From: Will Conway
Sent: Wednesday, February 21, 2018 3:56 PM
To: 'Jean Fraser'
Cc: 'Alexander M. Green'
Subject: Stormwater Comment Responses

Hello Jean, we have the following responses to the Wright Pierce Review Memo dated 2/7/18 :

SEBAGO TECHNICS
 75 John Roberts Rd., Suite 1A
 South Portland, ME 04065
 Tel: 207-209-2100
 Fax: 207-209-2100
 WWW.SEAGOTECHNICS.COM
 Tel: 207-283-5659

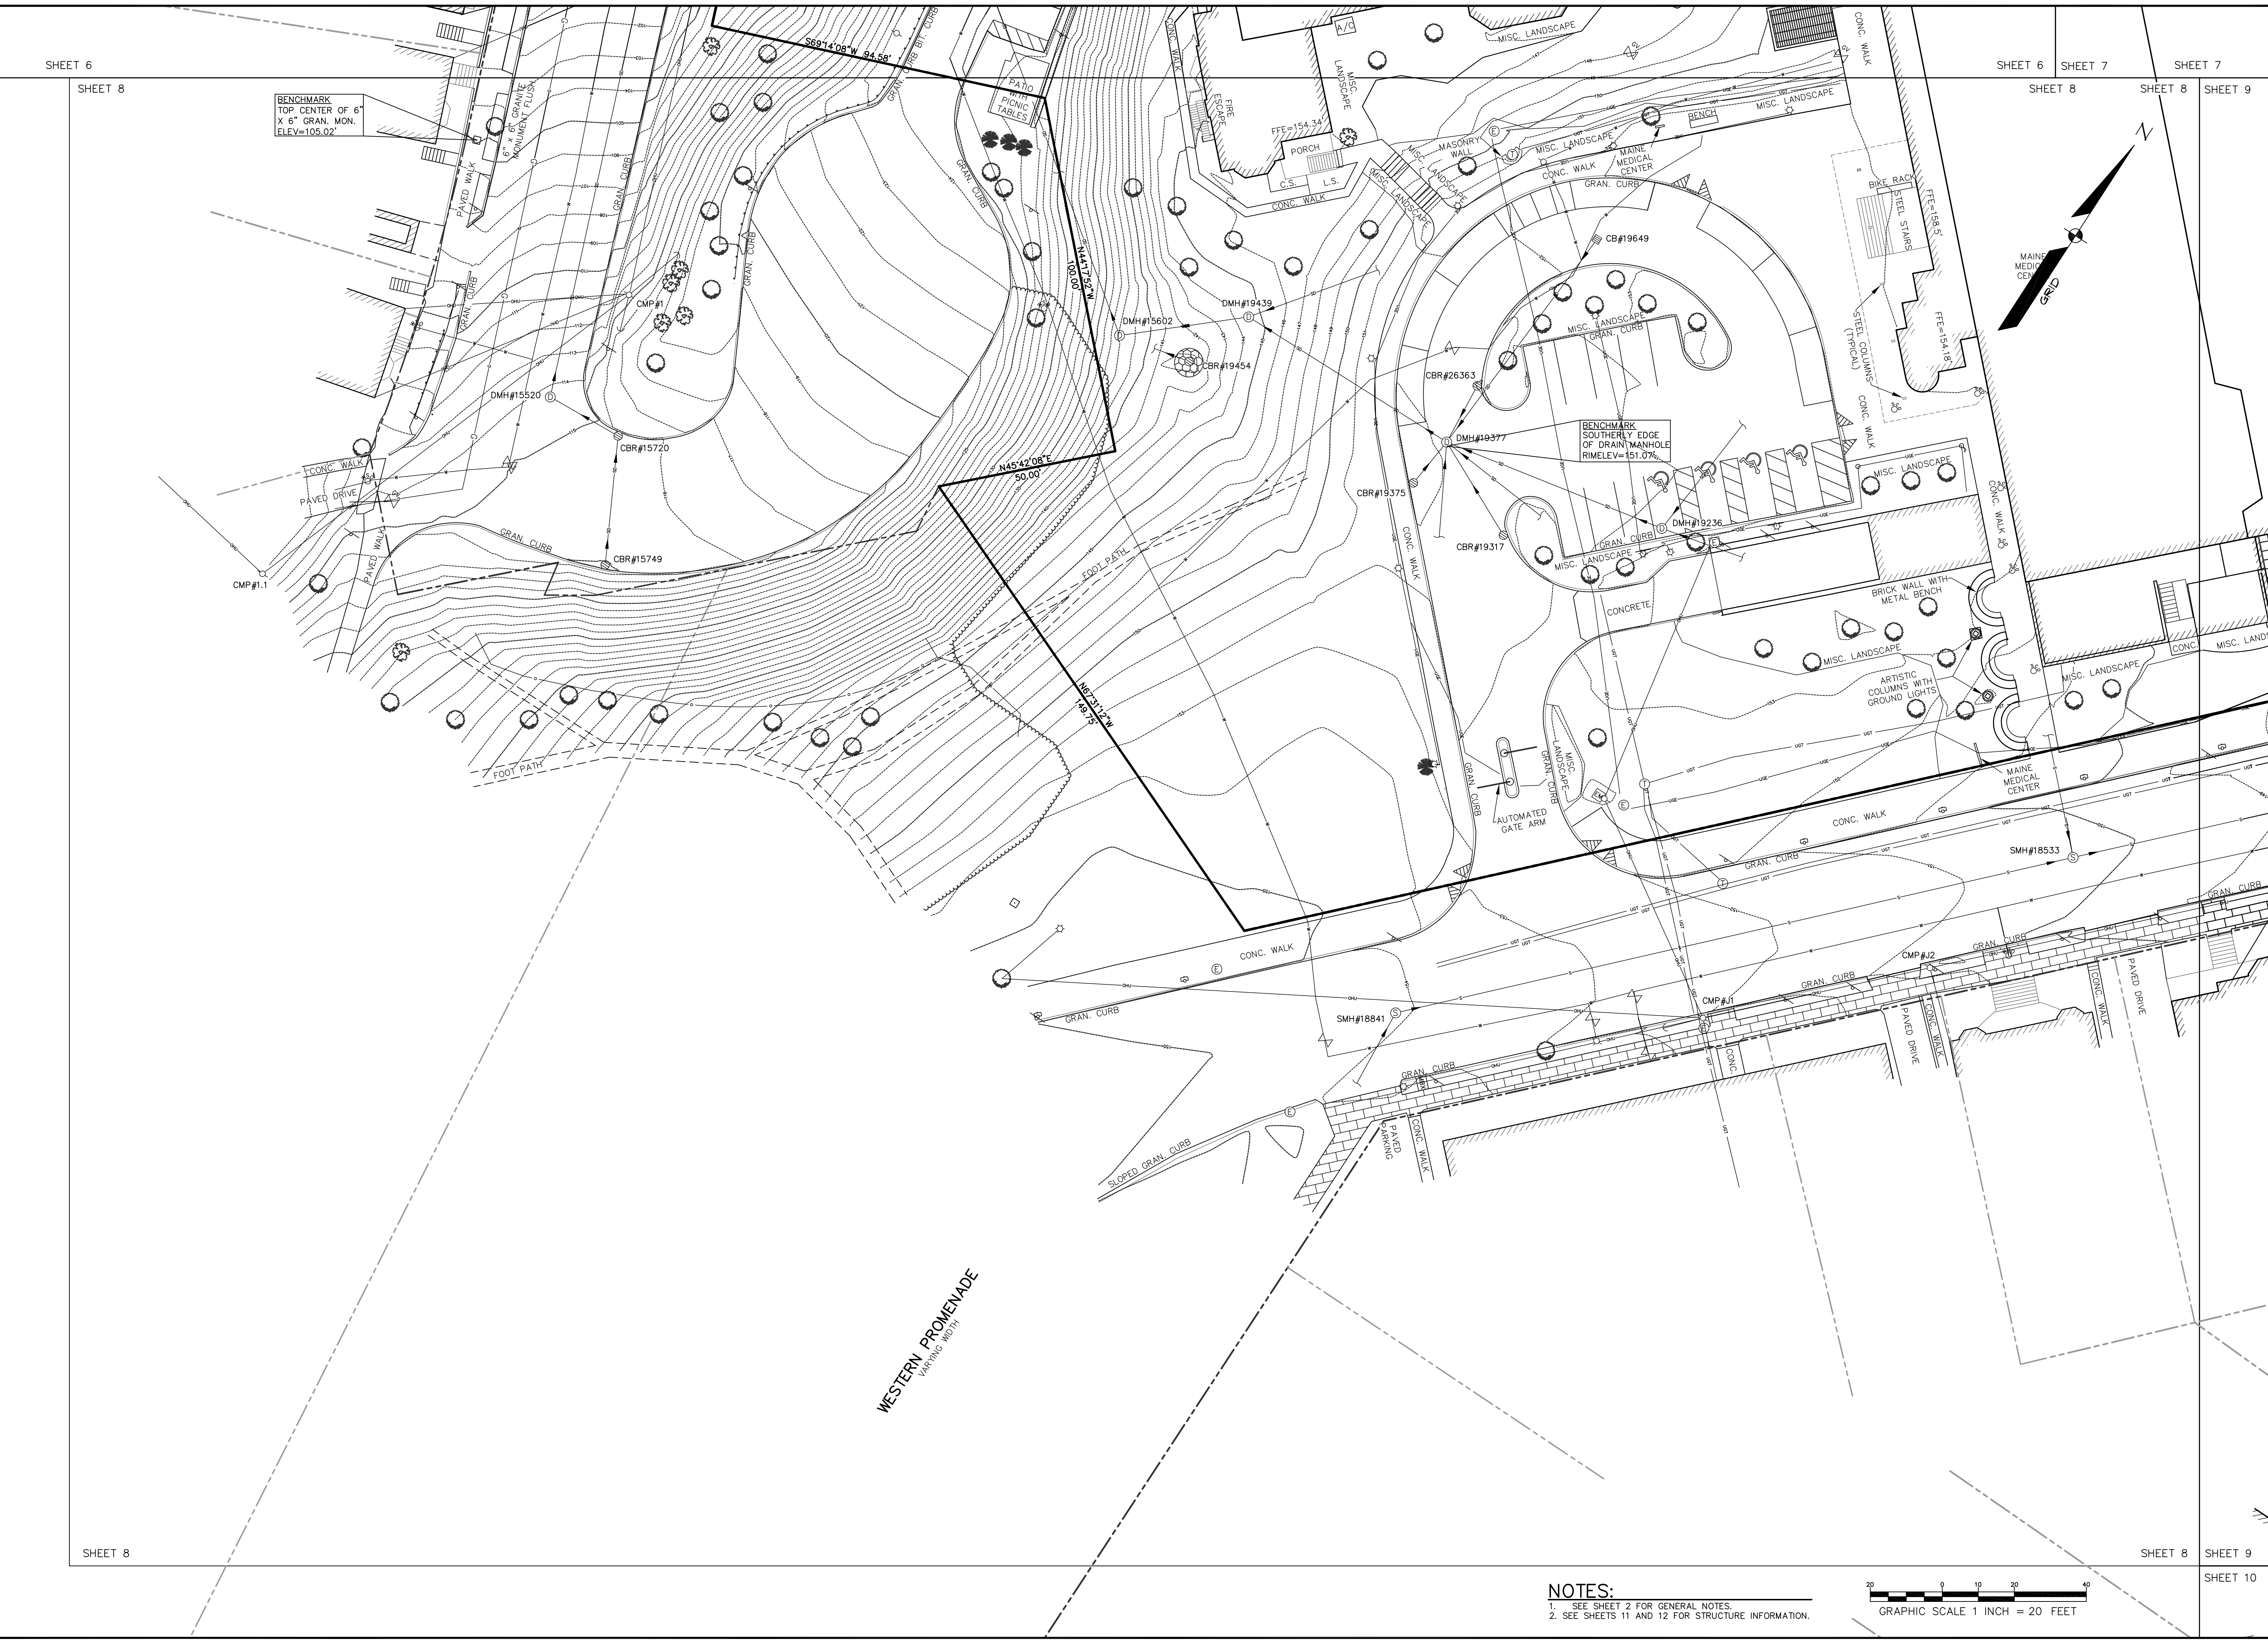
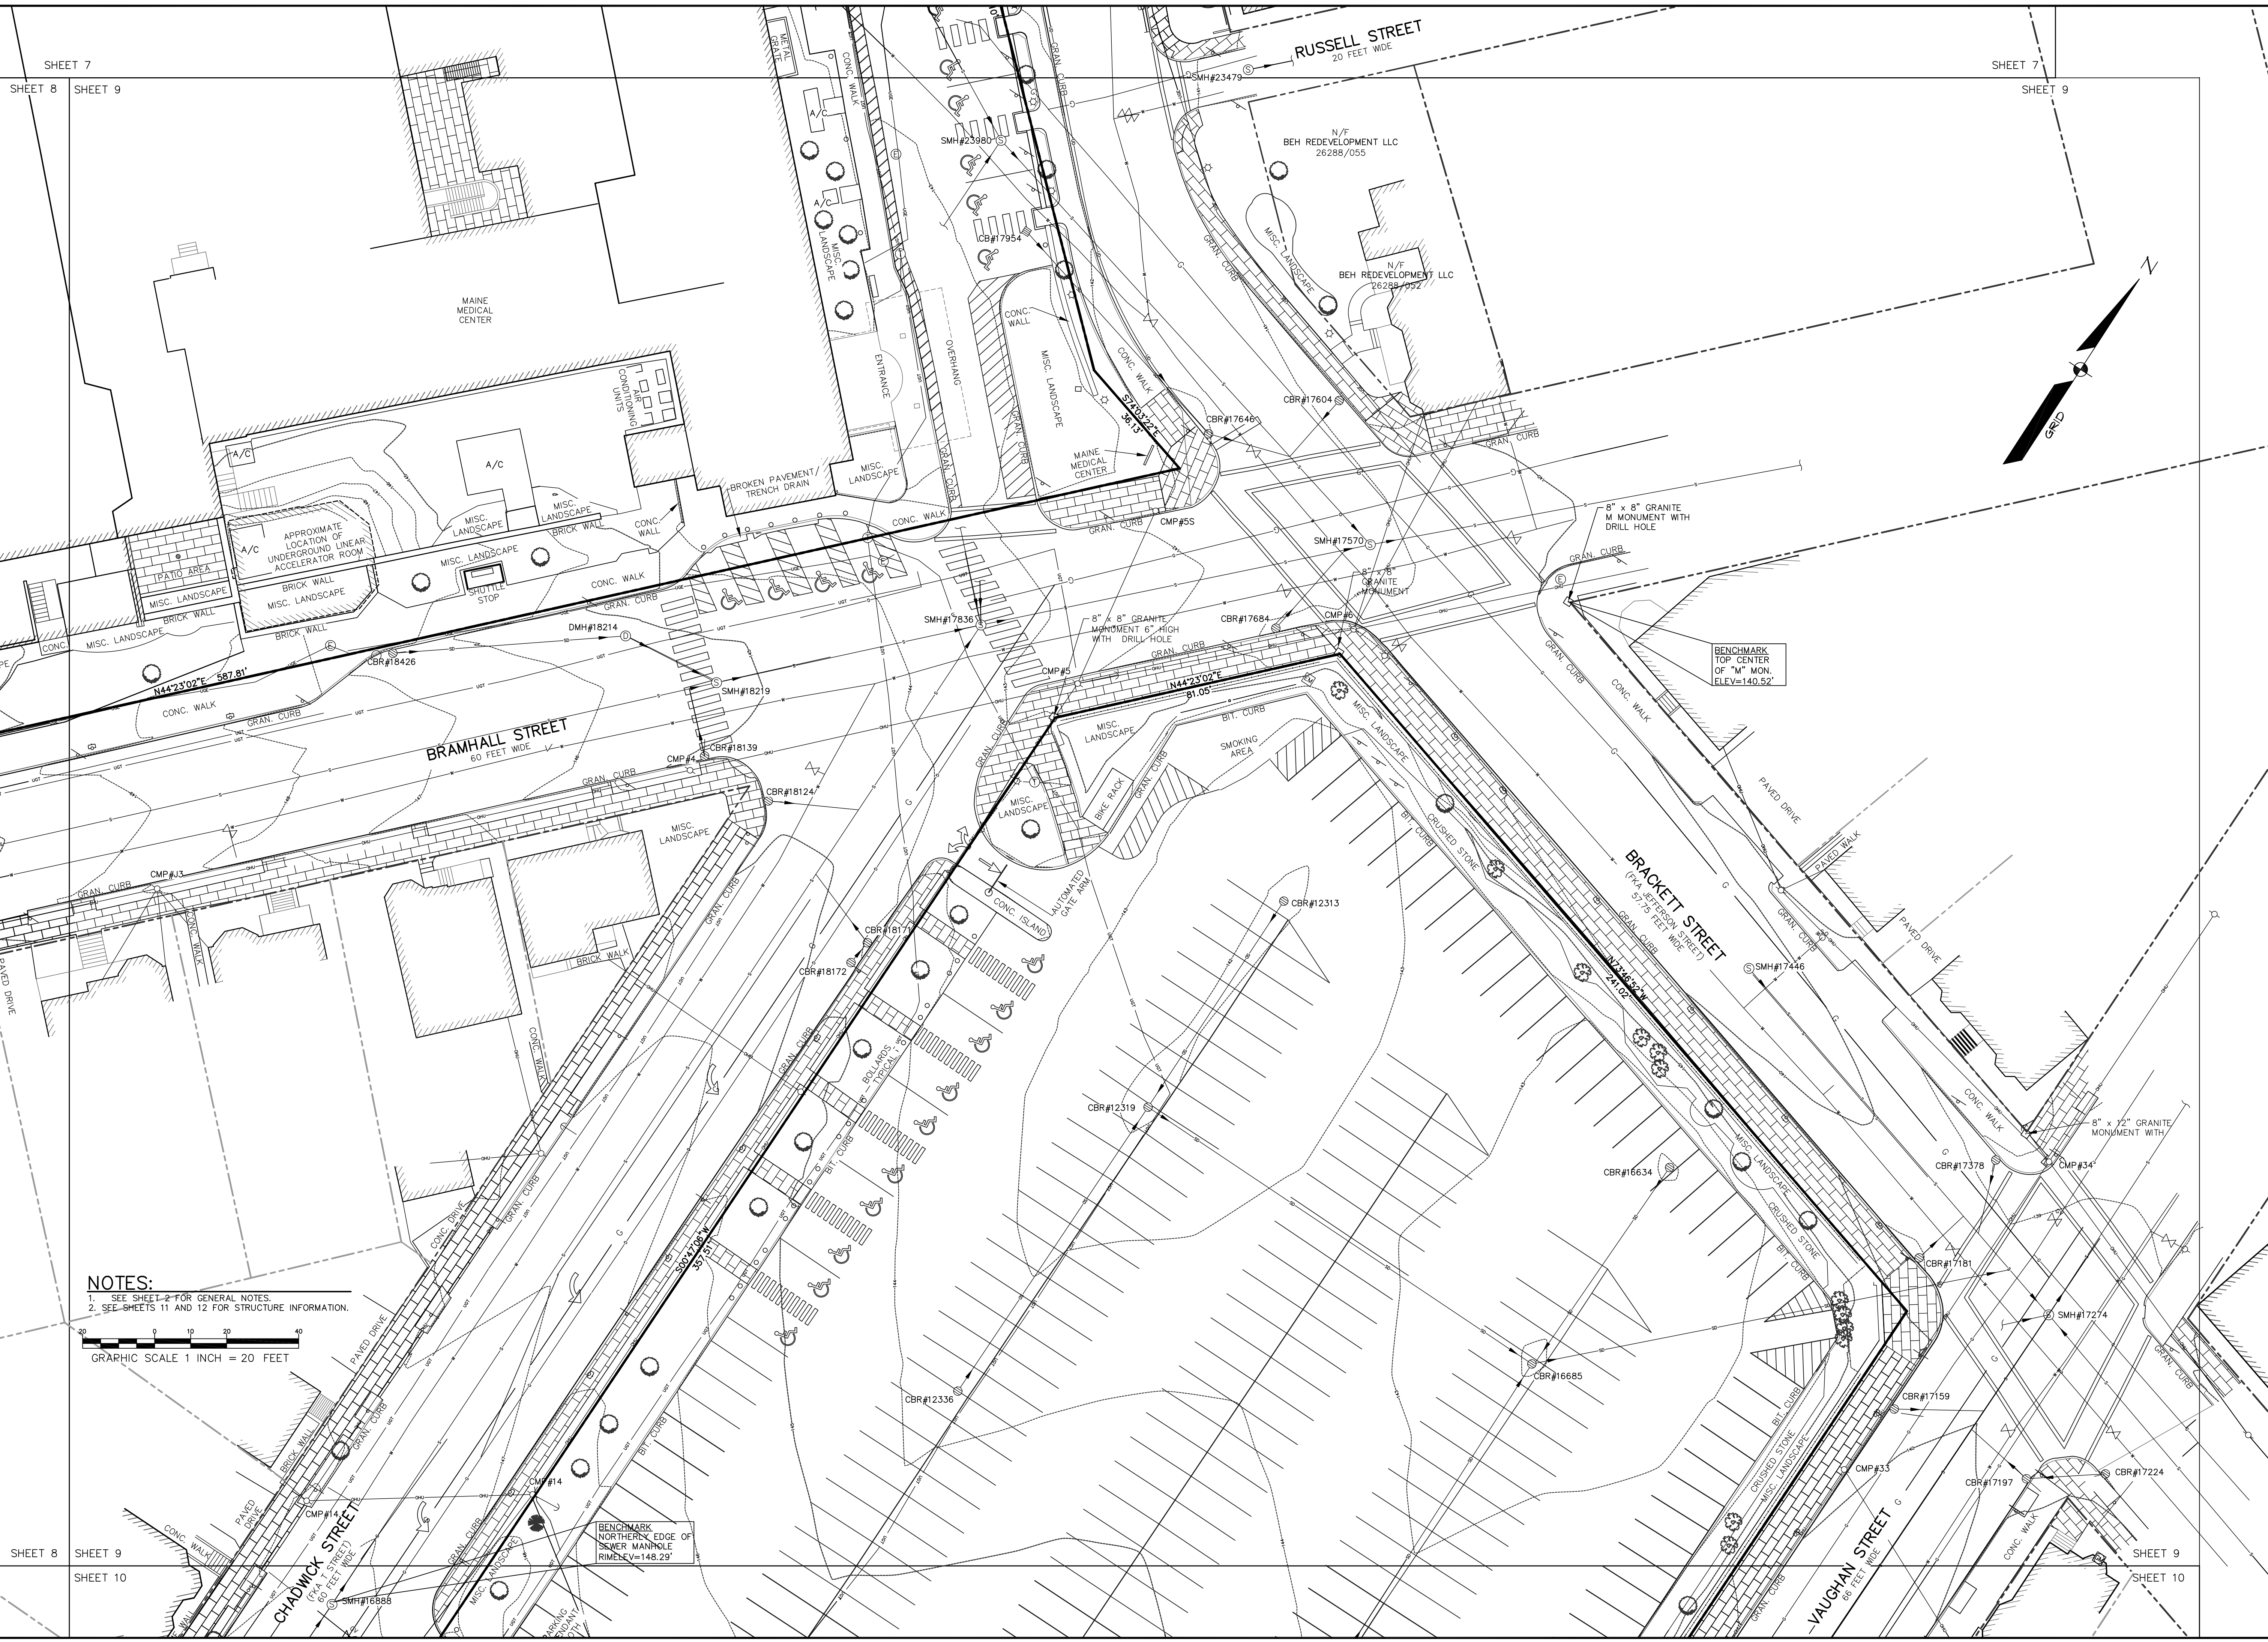
- Comment 1a – 1 c correctly state that Stormwater Basic, General and Flooding Standards do not apply to this project.
- Comment 3 (a) ii (1) requests that we submit an updated boundary survey with utility elevations, pipe sizes, and pipe materials added – that information is attached.
- Comment 3 (a) ii (2) AI will discuss this with Tuck.
- Comment 5(b) Regarding snow storage, MMC currently removes all snow from the site, and this will be the case in the future.

The updated boundary survey is saved in EPlan under plans / Plan2K Boundary Survey February 21
